From: Plant, Tom - Communities <Tom.Plant@Oxfordshire.gov.uk>
Sent: 18 September 2019 15:40
To: Caroline Ford
Cc: DC Support; Cllr Ian Corkin
Subject: 19-01600-F - Bicester Gateway Business Park Wendlebury Road Chesterton

Planning application: 19/01600/F
Location: Bicester Gateway Business Park Wendlebury Road Chesterton
Description: Compound and enclosure for siting of 3 no. LPG tanks within car park of approved hotel
Type: Full Development
Case Officer: Caroline Ford

01 SITE SETTING OUT MASTER Copy 1  
1:50

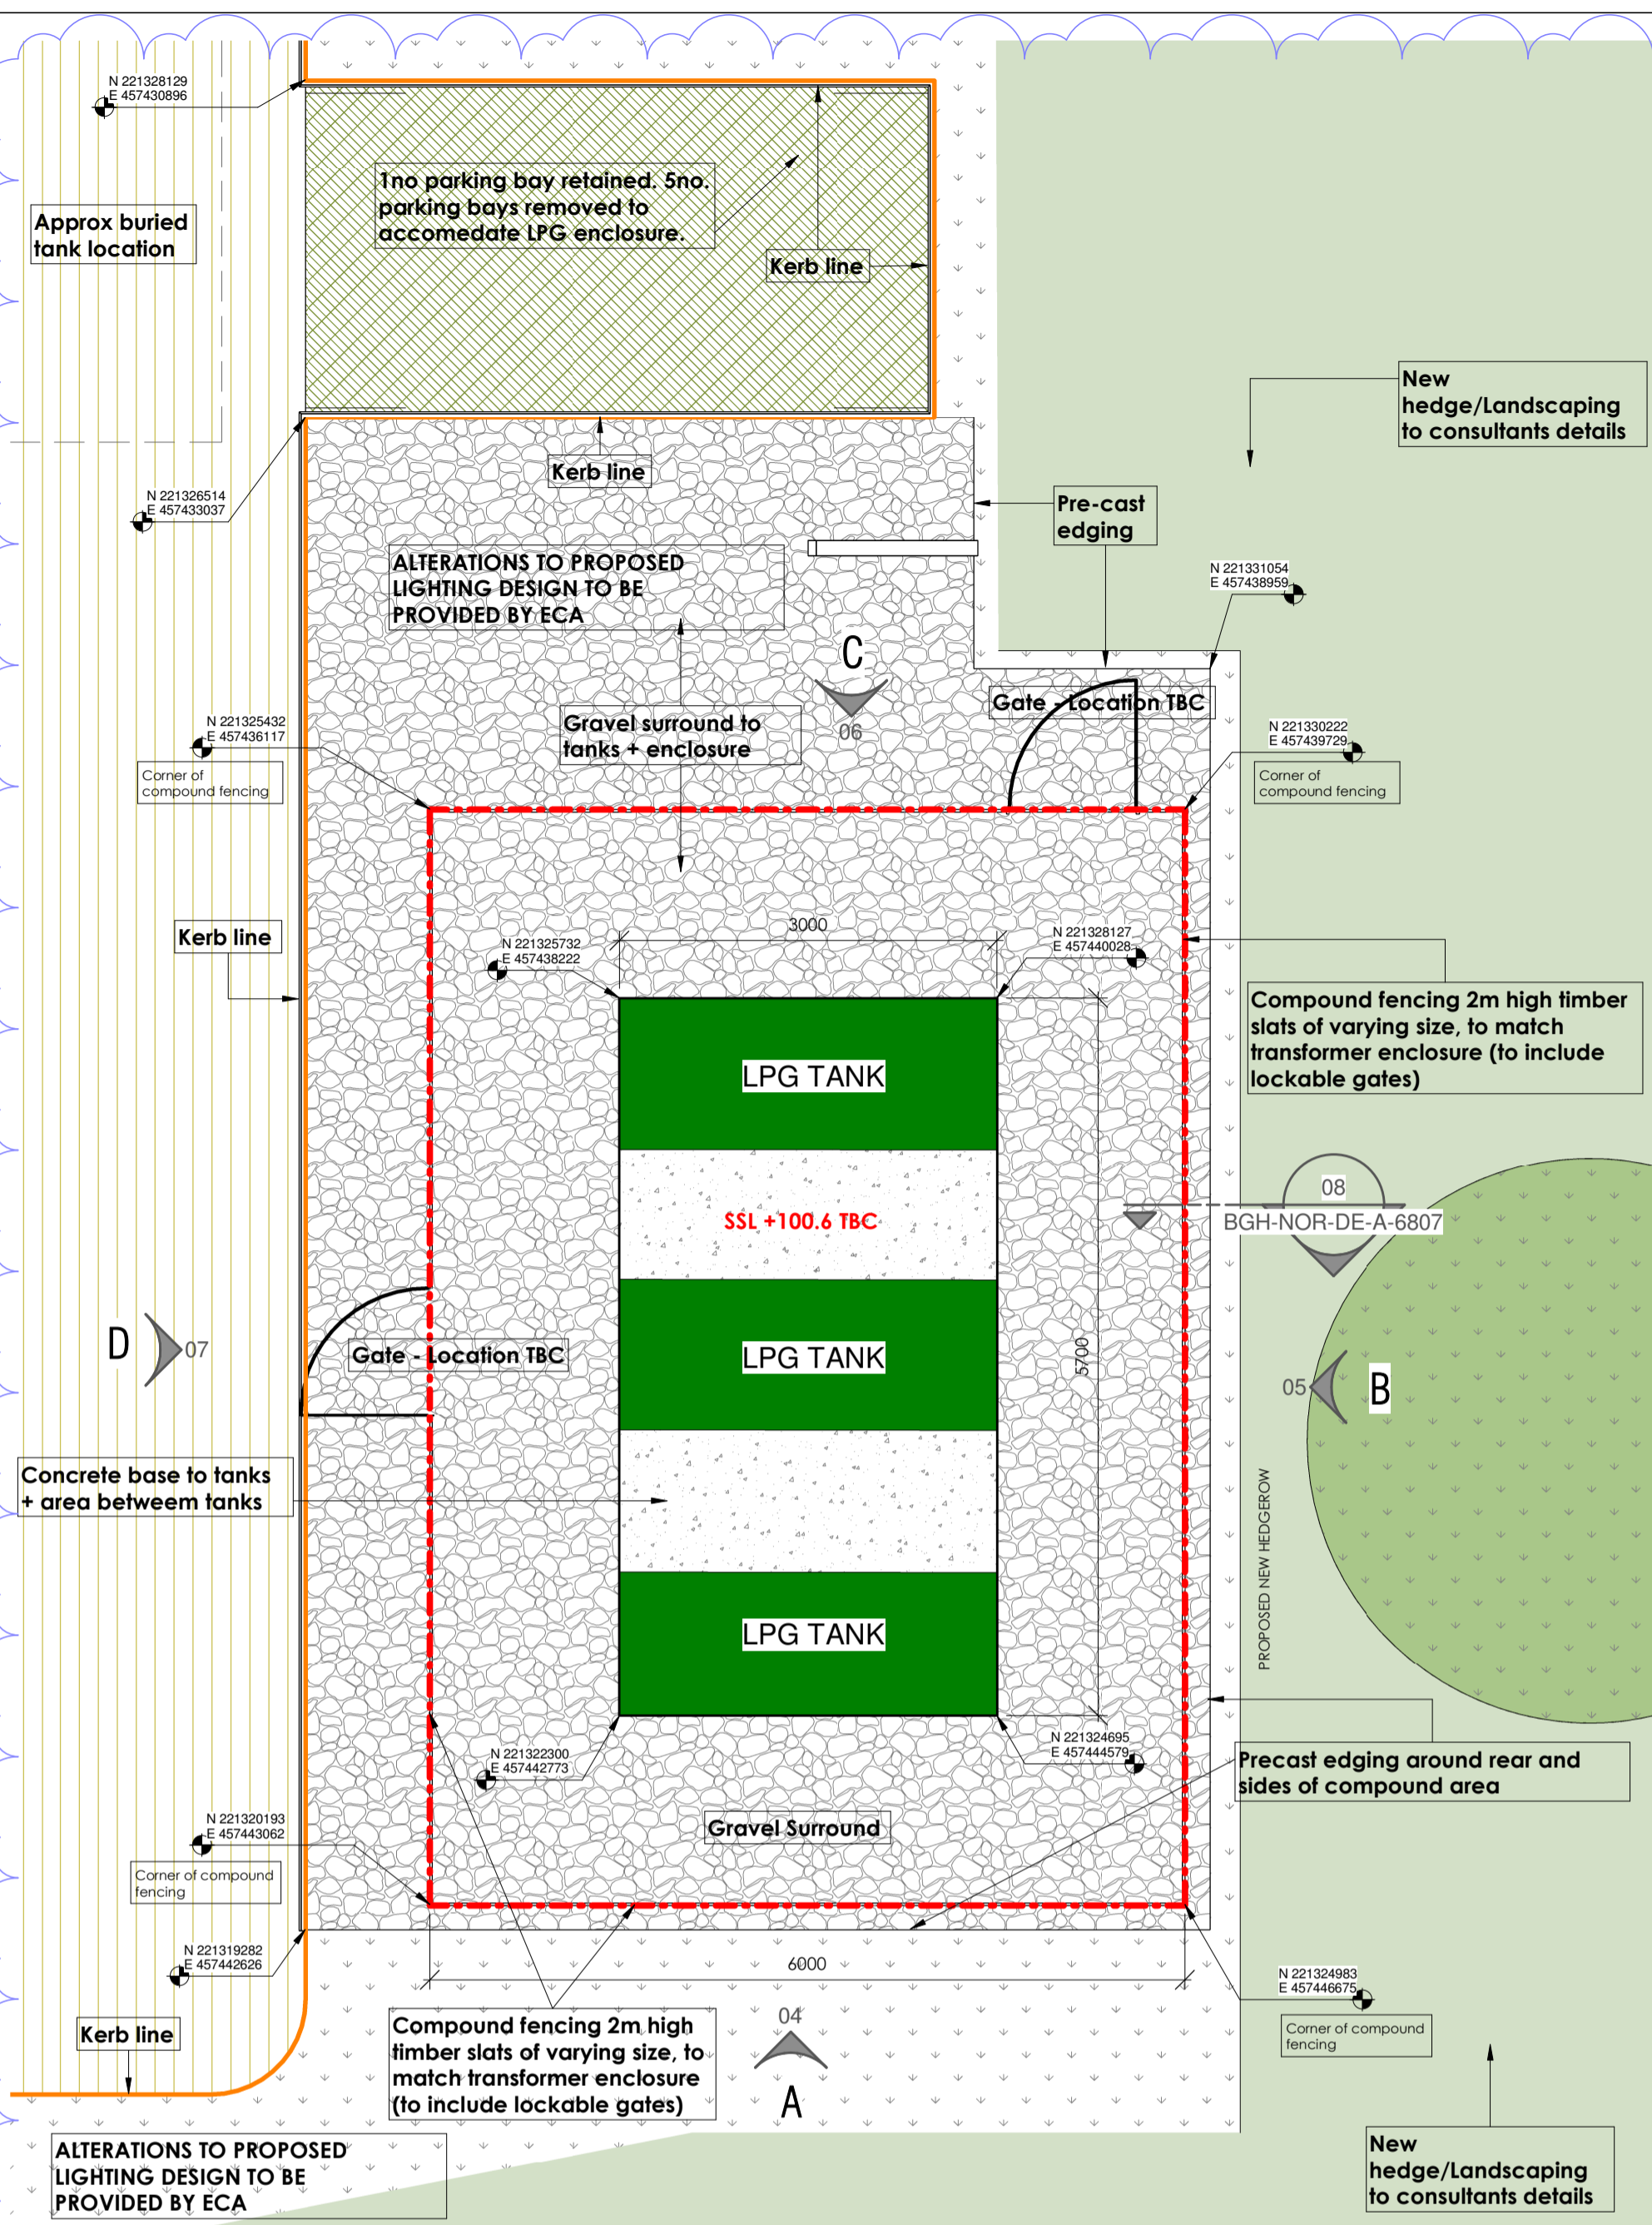
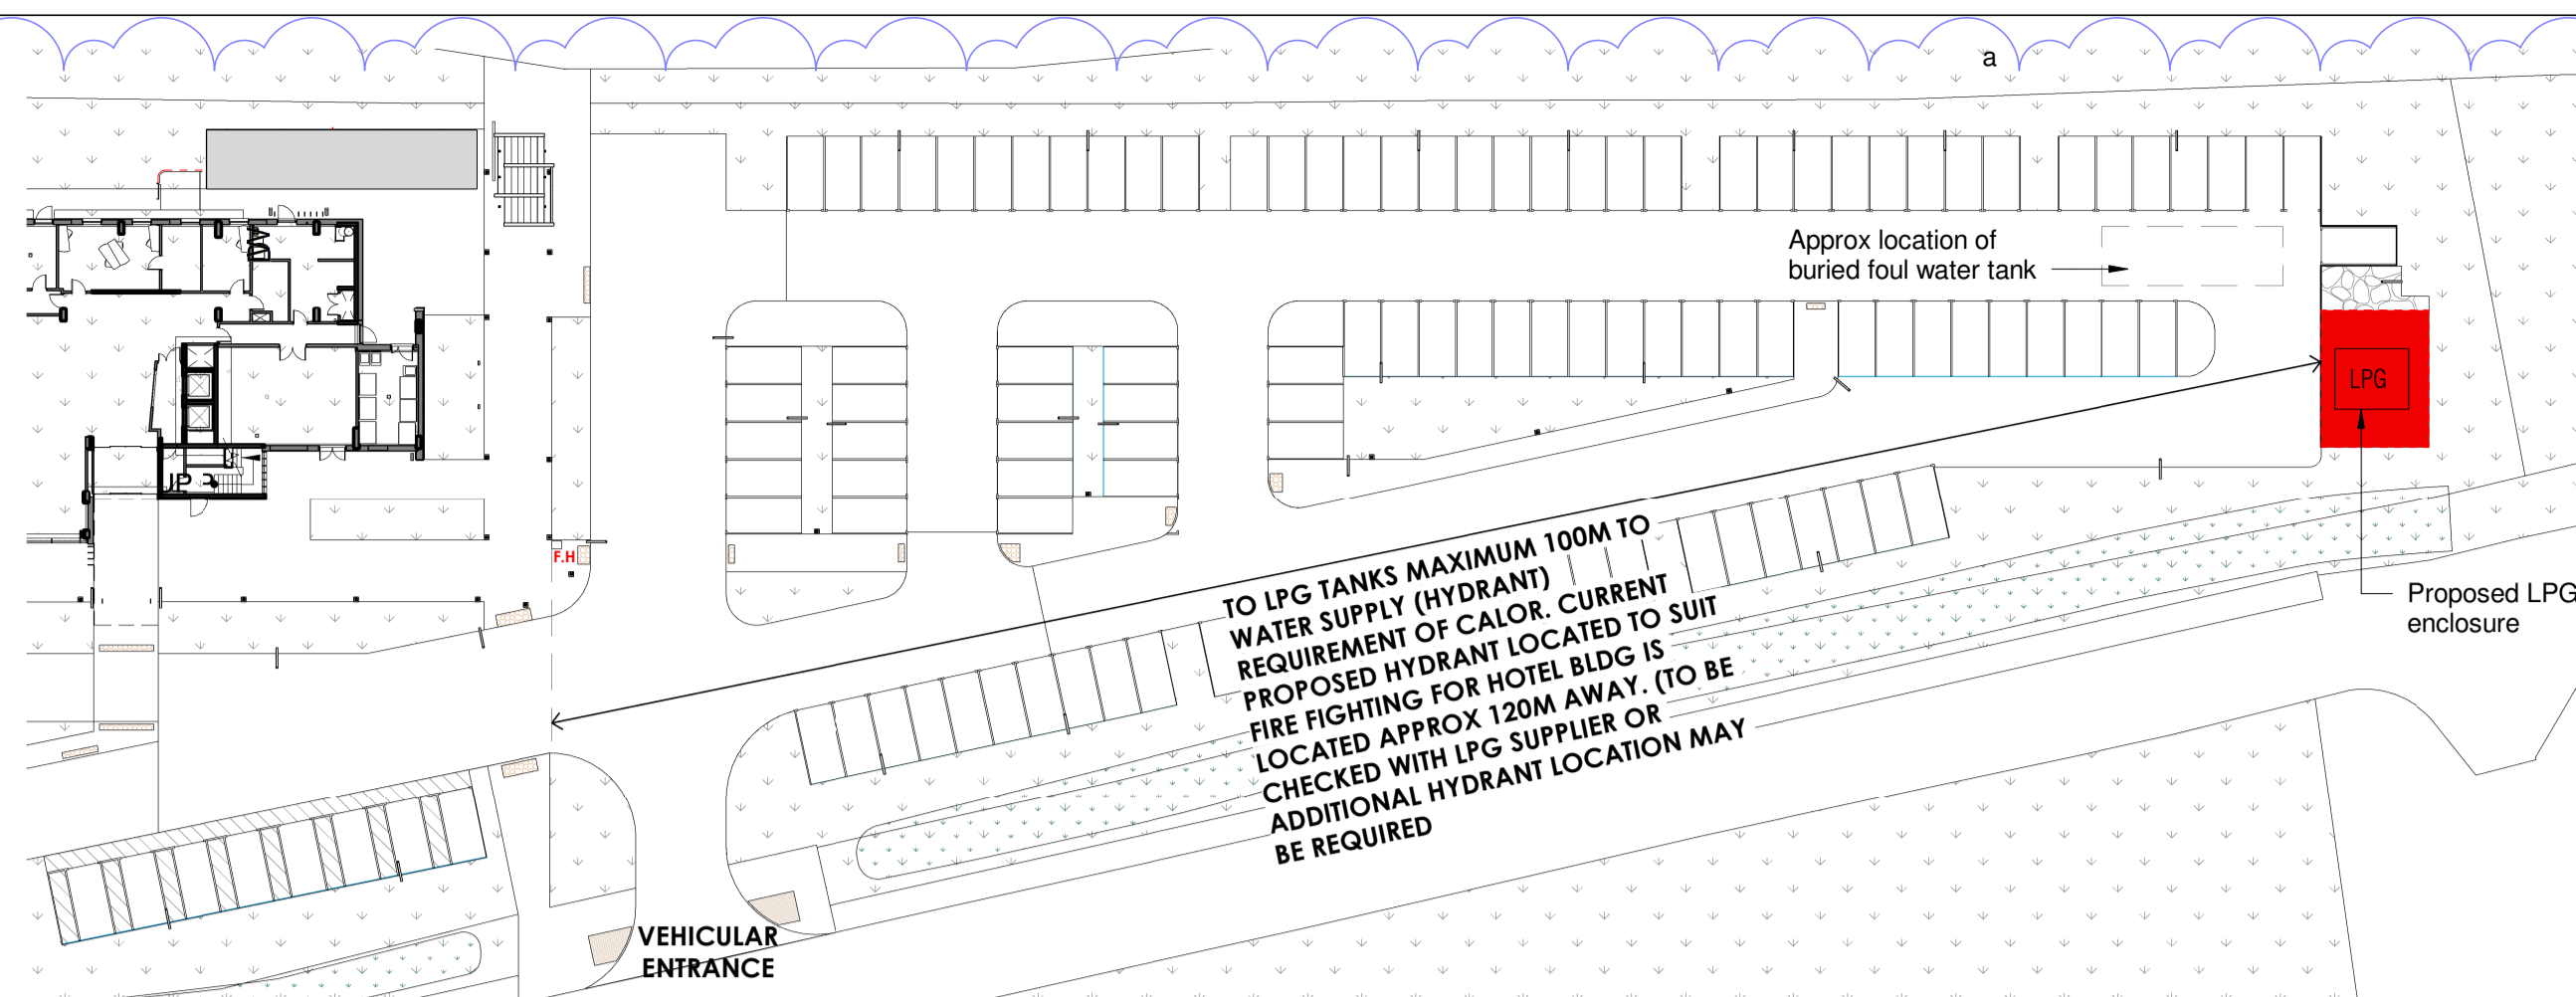
The proposals whilst will lead to a loss of 5 parking spaces, were a situation to arise that the hotel is at full occupancy, other parking opportunities exist within the vicinity including the park and ride site on the opposite side of the Vendee Drive roundabout with the A41. Therefore, the proposals are unlikely to have any adverse impact upon the local highway network from a traffic and safety point of view, therefore I offer no objection.
